**WELWYN HATFIELD BOROUGH COUNCIL
EXECUTIVE DIRECTOR - PLANNING, PUBLIC PROTECTION AND GOVERNANCE**

Application No: 6/2020/3347/PN27
Location: Manor Cottage Vineyards Road Northaw Potters Bar EN6 4PQ
Proposal: Prior approval for an additional storey on the existing property
Officer: Mr Sukhdeep Jhooti

Recommendation: Prior Approval Required and Granted

Project: Manor Cottage, Vineyards Road, Northaw, EN6 4PQ  
 Drawn By: tmh  
 Date Drawn: 15/09/2020  
 Drawing Title: Proposed Elevations A1  
 Drawing Number: TDC065/ PL/102  
 Scale @ A1: 1:100  
 Rev: C

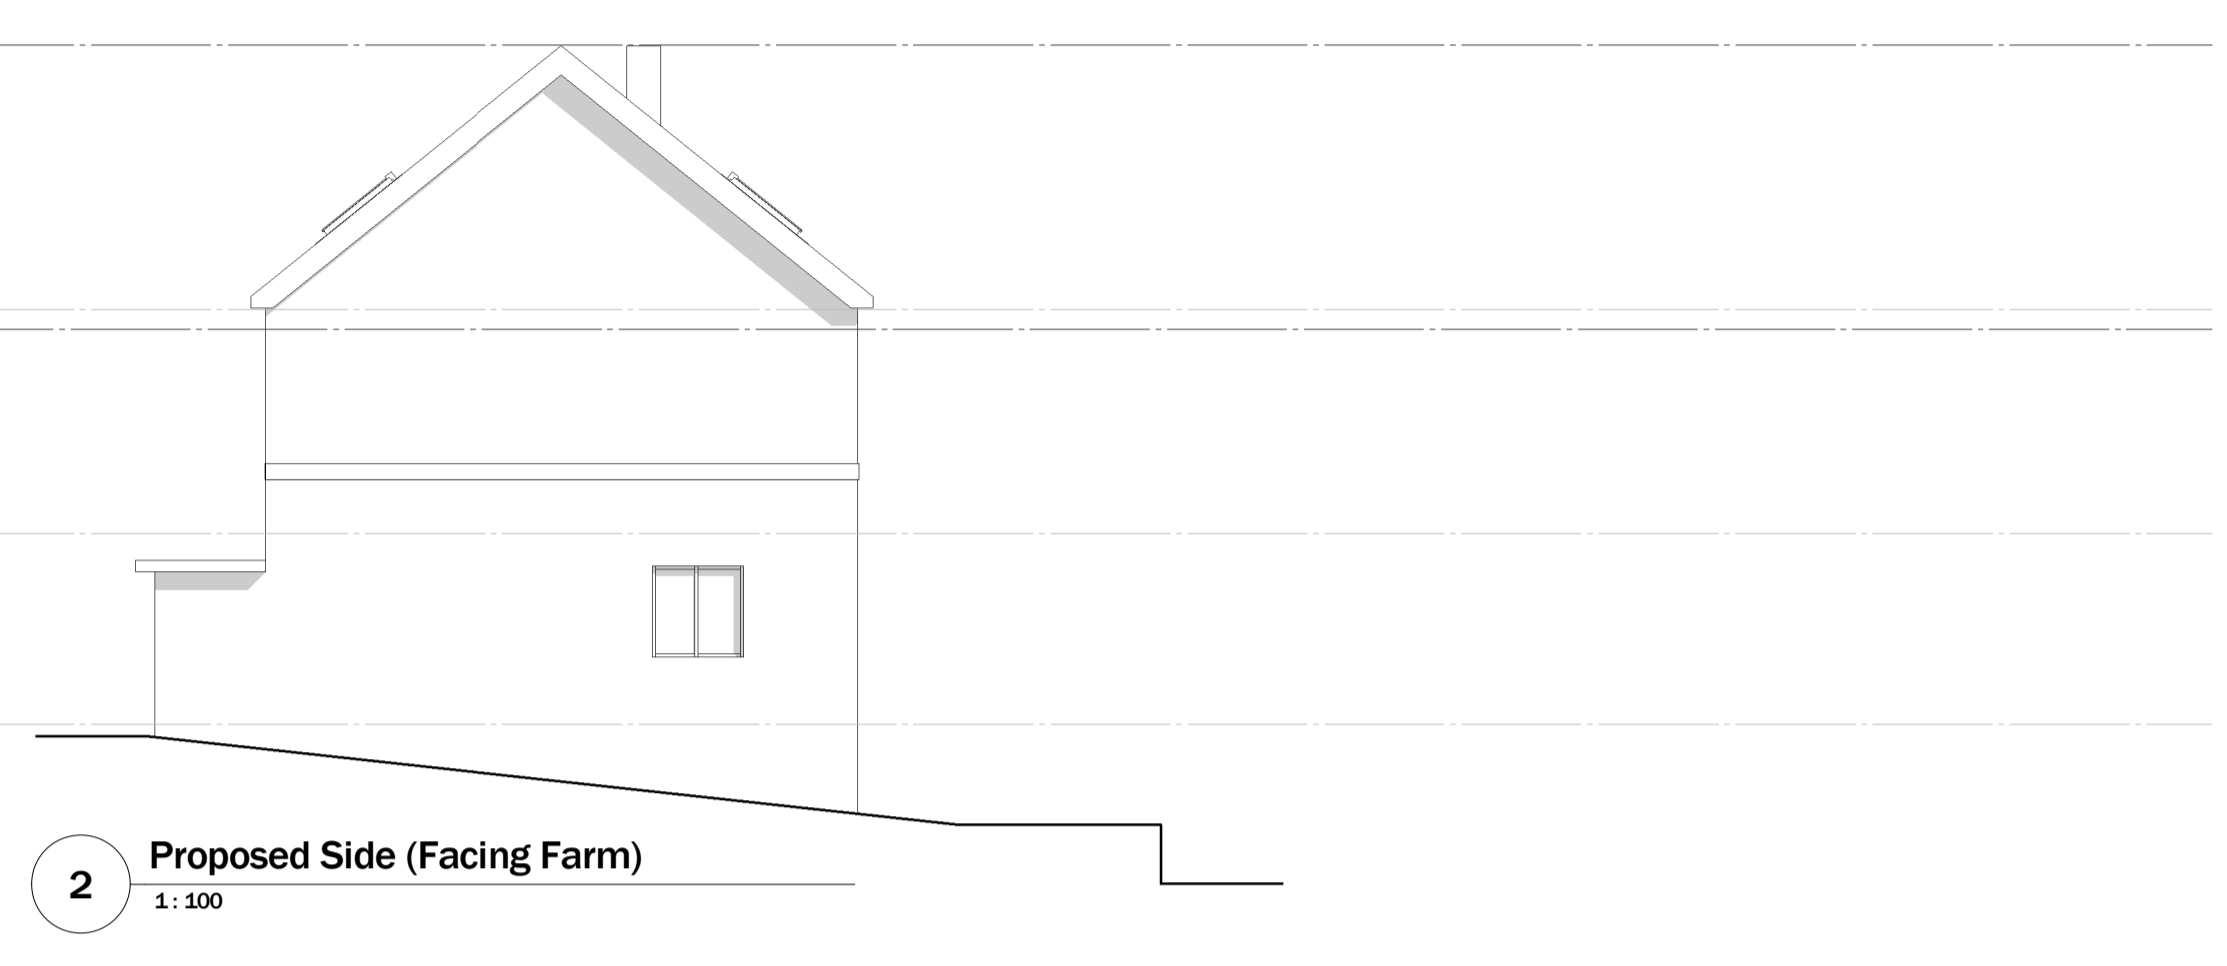
<p>surrounding properties to prevent a substantial impact occurring any impact with regard to an overbearing impact or a loss of light.</p> <p>In terms of privacy, the front windows within the new storey of the existing dwelling would afford views towards the north of the site and towards the residential garden of Nyn Manor Cottage. Nonetheless, the rooms the windows would serve consist of three bathrooms and two wardrobes. It is therefore unlikely that extended periods of time would be spent in these rooms compared to the main habitable rooms at the property. Rooflights would also be installed in the roof space of the resultant second floor which would be modest in scale and serve bedrooms and a landing area. All of the proposed windows/rooflights on the front of the proposed dwelling are labelled as being obscure glazed on the submitted plans, therefore, the resulting relationship would be unlikely to significantly impact upon the privacy of the occupiers of Nyn Manor Cottage. Subsequently the resulting relationship would not result in an undue loss of privacy.</p>

<p>External Appearance</p>	<p>In accordance with section AA.2 (3) (a) (ii) of Schedule 2, Part 1, Class AA of The Town and Country (General Permitted Development) Order 2015 (as amended), the local planning authority shall consider the external appearance of the dwellinghouse, including the design and architectural features of the following:</p> <p>(aa)the principal elevation of the dwellinghouse, and (bb) any side elevation of the dwellinghouse that fronts a highway.</p> <p>The existing property is finished with a pitched, gable-end style roof and benefits from single storey elements including a front extension with a flat roof and a conservatory to the side. These elements appear as subordinate additions to the main dwelling.</p> <p>The proposed additional storey would be visible from public vantage points as well as from neighbouring dwellings and their gardens. The proposal indicates a pitched gable-end roof above the main dwelling with a single storey flat roof projection as per existing. The roof design of the resultant dwelling would be in keeping with the existing dwelling. The proposal would adequately reflect and relate to the design and character of the host dwelling.</p> <p>It is acknowledged that the applicant has attempted to replicate the existing pattern of fenestration on the additional storey and resulting roof slope via the addition of numerous windows and rooflights on both the front and rear elevation of the dwelling.</p> <p>The level of rooflights proposed have been reduced from the previous refusal and the proposed rooflights would now not appear over-dominant within the roofslopes of the application dwelling in terms of their number, size, scale and profile. The proposed glazing would be well-positioned and proportionate. It would not now result in an unduly cluttered appearance. The existing dwelling has a lot of glazing at present so the proposed fenestration would not appear unusual or out of character with the existing house.</p>
